**Gatwick Airport Northern Runway Project
Development Consent Order
Planning Inspectorate's Reference: TR020005**

**Deadline 6 Representation from Rusper Parish Council
Re Noise Contours & Proposed Revised Noise Insulation Scheme**

Drawn date:
September 2023

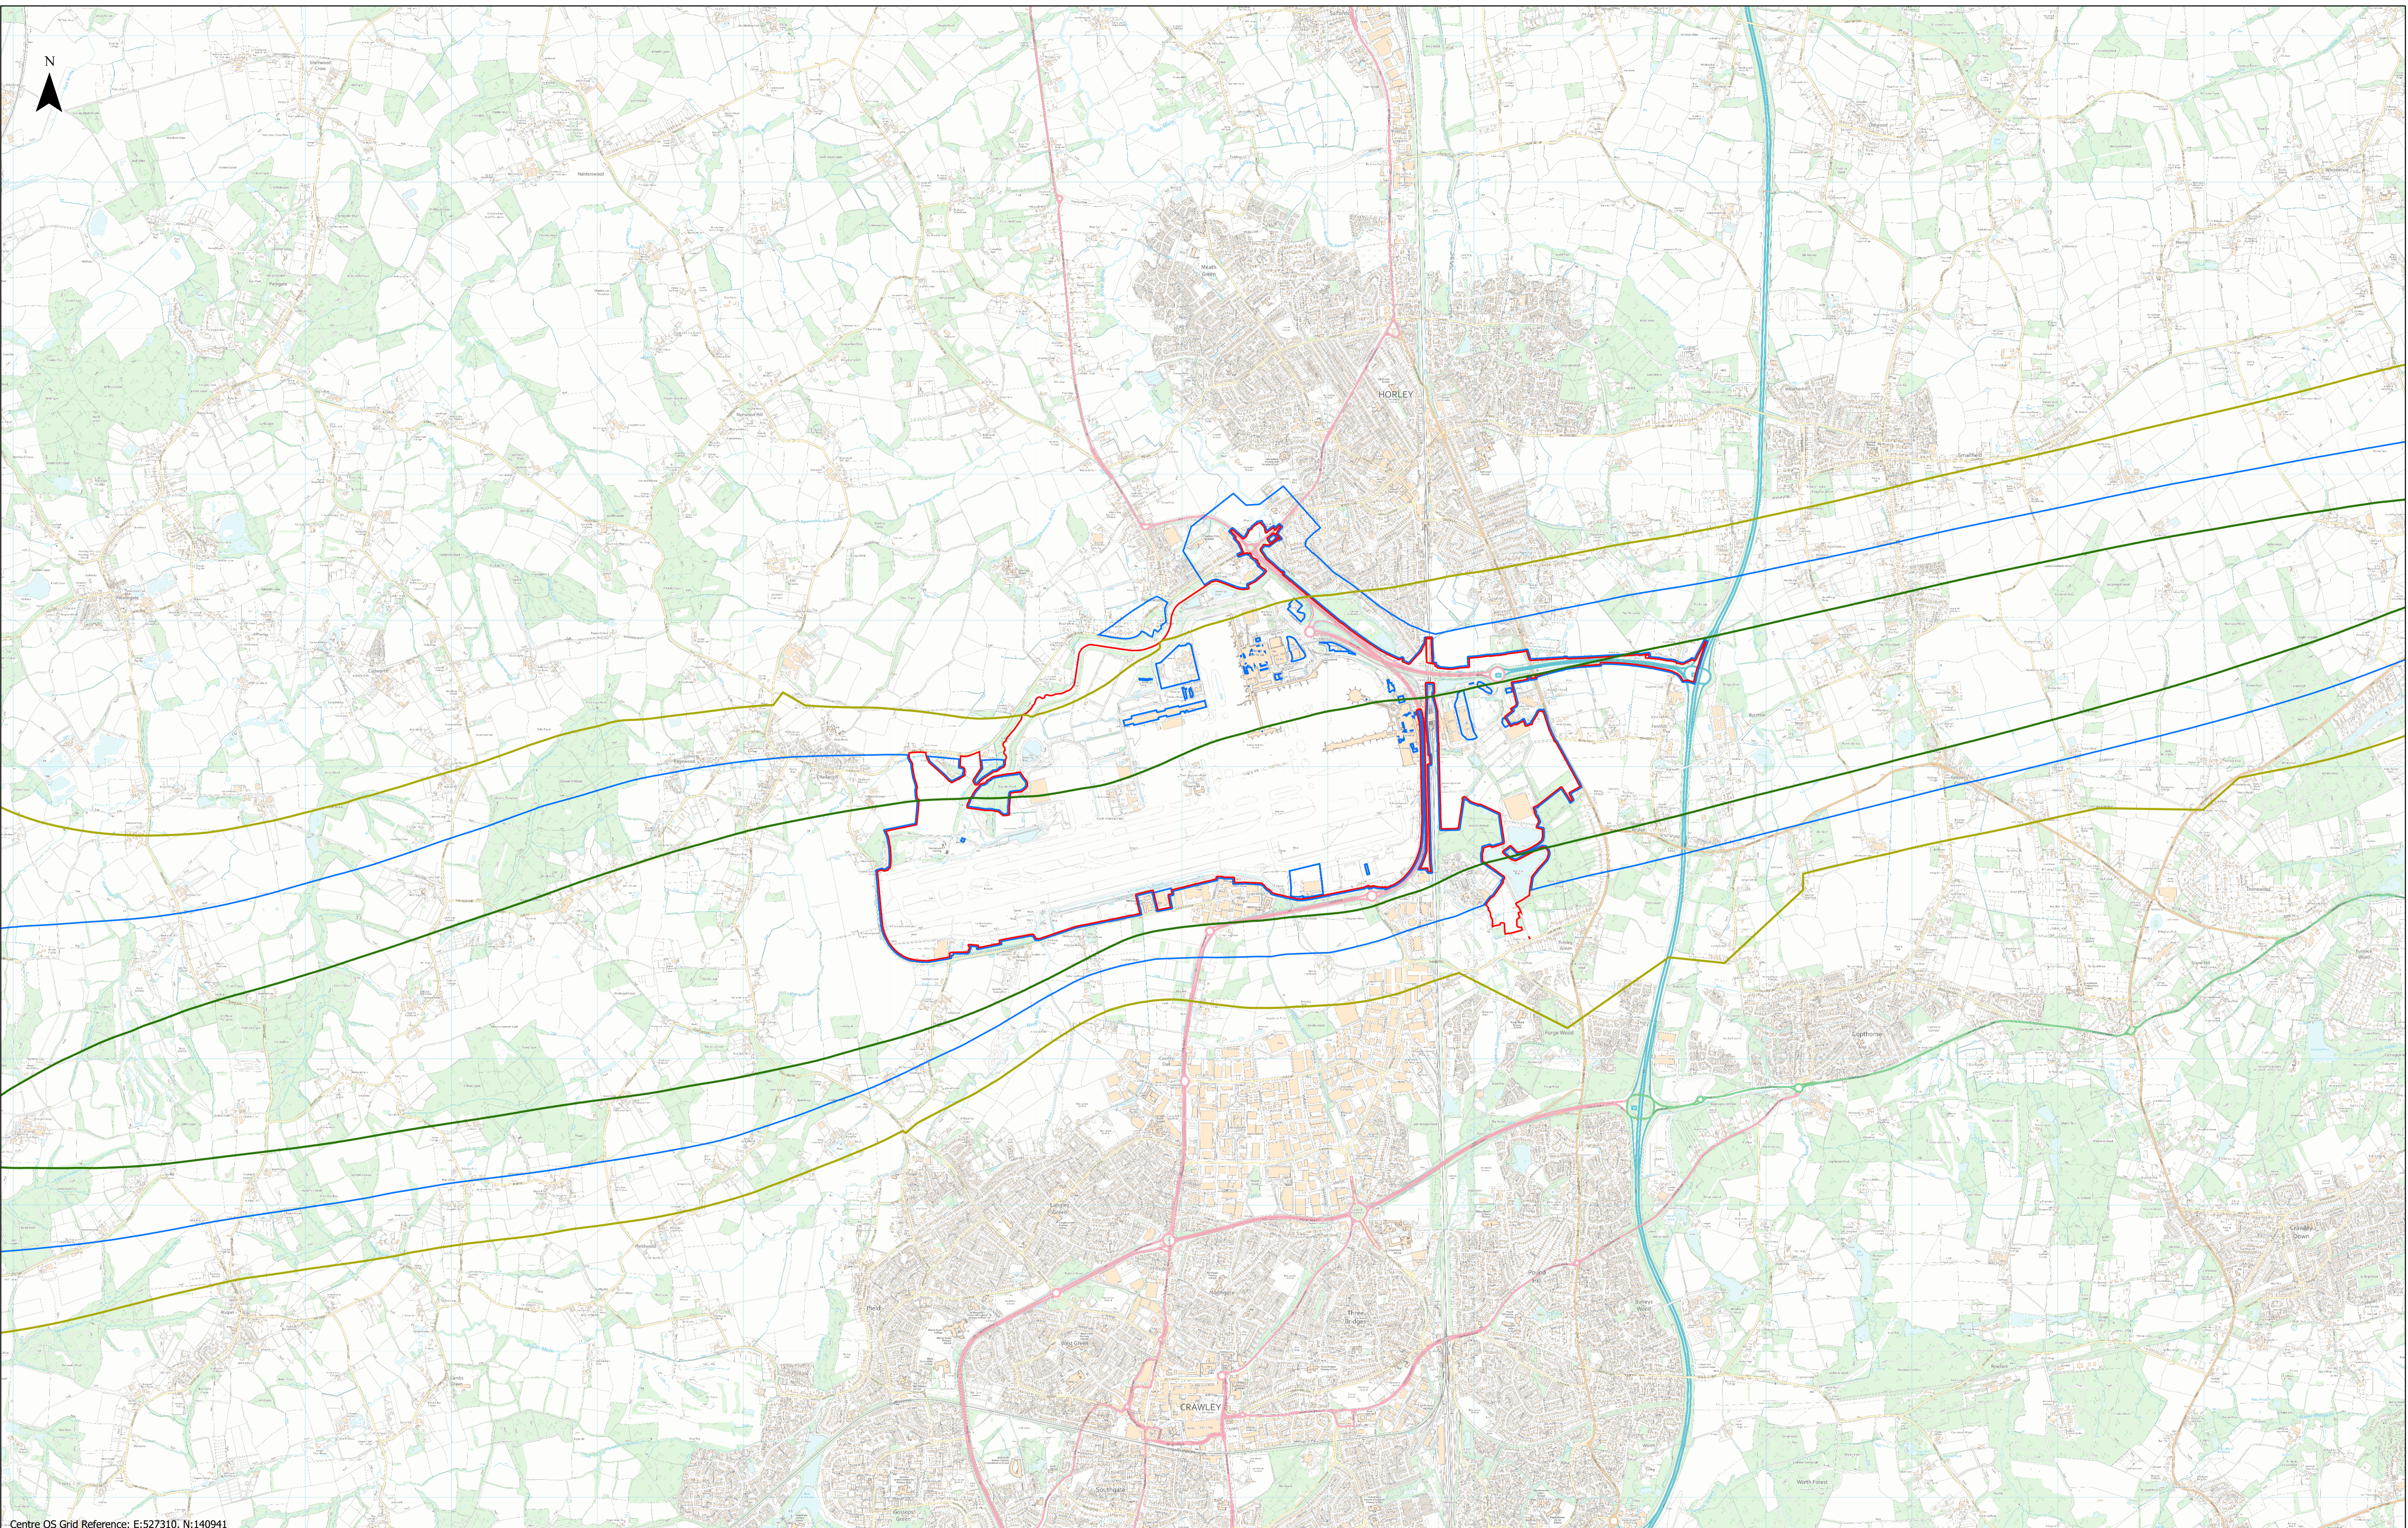
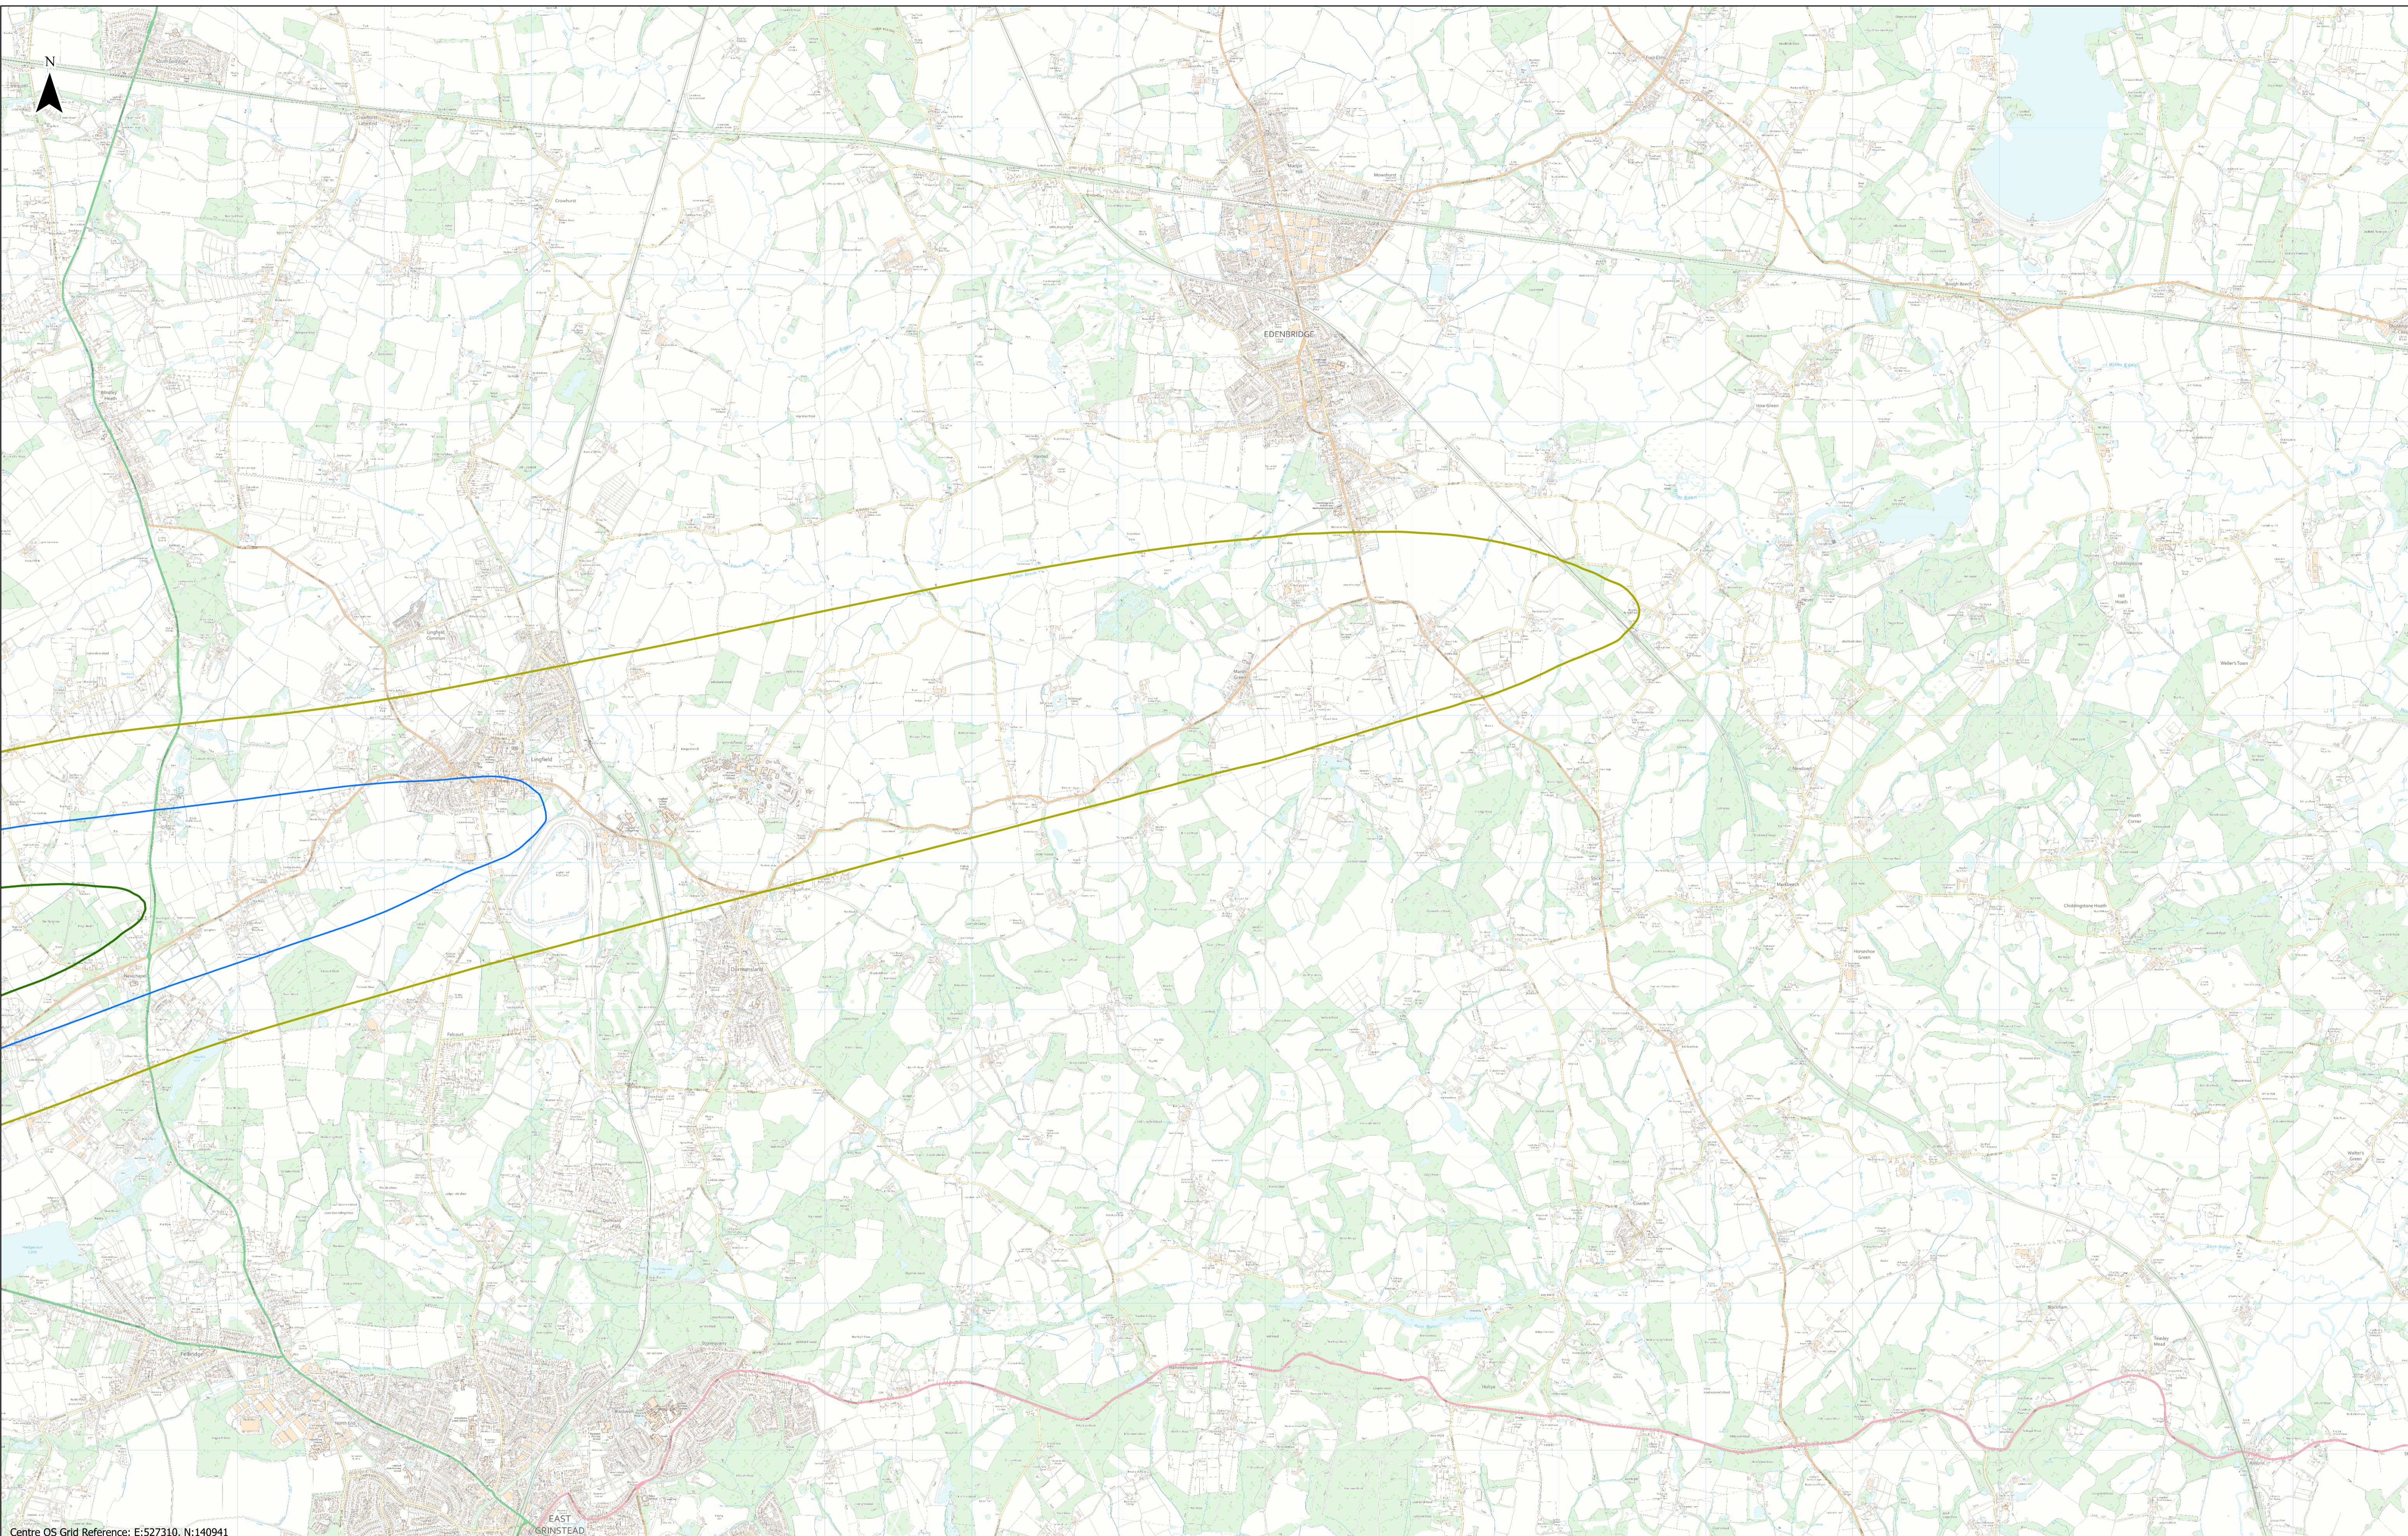
We would also wish that the Noise Contour maps be materially upgraded since it is extremely difficult to ascertain precisely where the contours are. It is not made clear when these contour maps were compiled nor the data used in their compilation. It is thought they may simply have been prepared at the time of the Second Runway proposals in 2014.

More particularly, since detailed interpretation of the proposed contours is problematic, Gatwick should set out their proposed contours using Google maps (or similar) so that the position of roads and individual houses are made much clearer.

One issue which needs clarification is that Gatwick states their present scheme operates within a boundary of 60dB daytime Leq, whereas it would seem that their proposals now revert to 63dB daytime Leq. Since this effectively reduces the size of the noise contour and thus the eligibility of residents who were within the 60dB contour but not within the 63dB contour, the change is not explained nor justified.
